## Appendix A. Response to Submissions and Conditions Table

30 October 2017

Subject: Response to Submissions

Landscape Design Plan

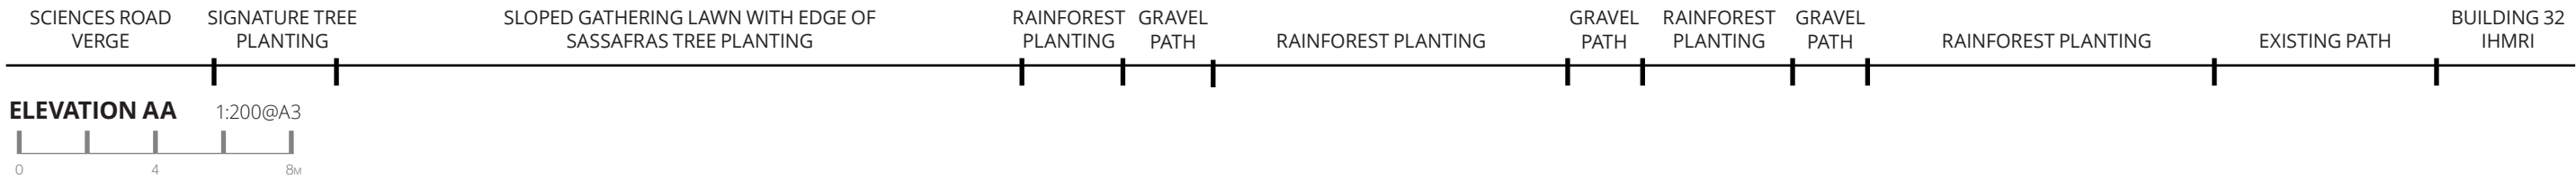
<b>Landscaping</b> <ul style="list-style-type: none"> <li>The submission of a final Landscape Plan should be required in accordance with the requirements of Wollongong City Council DCP 2009 Chapter E6 and the approved Landscape Plan (i.e. as part of this consent).</li> <li>The submission of certification from a suitably qualified and experienced landscape designer and drainage consultant should be provided prior to commencement of works confirming that the landscape plan and the drainage plan are compatible.</li> </ul>	Condition Accepted
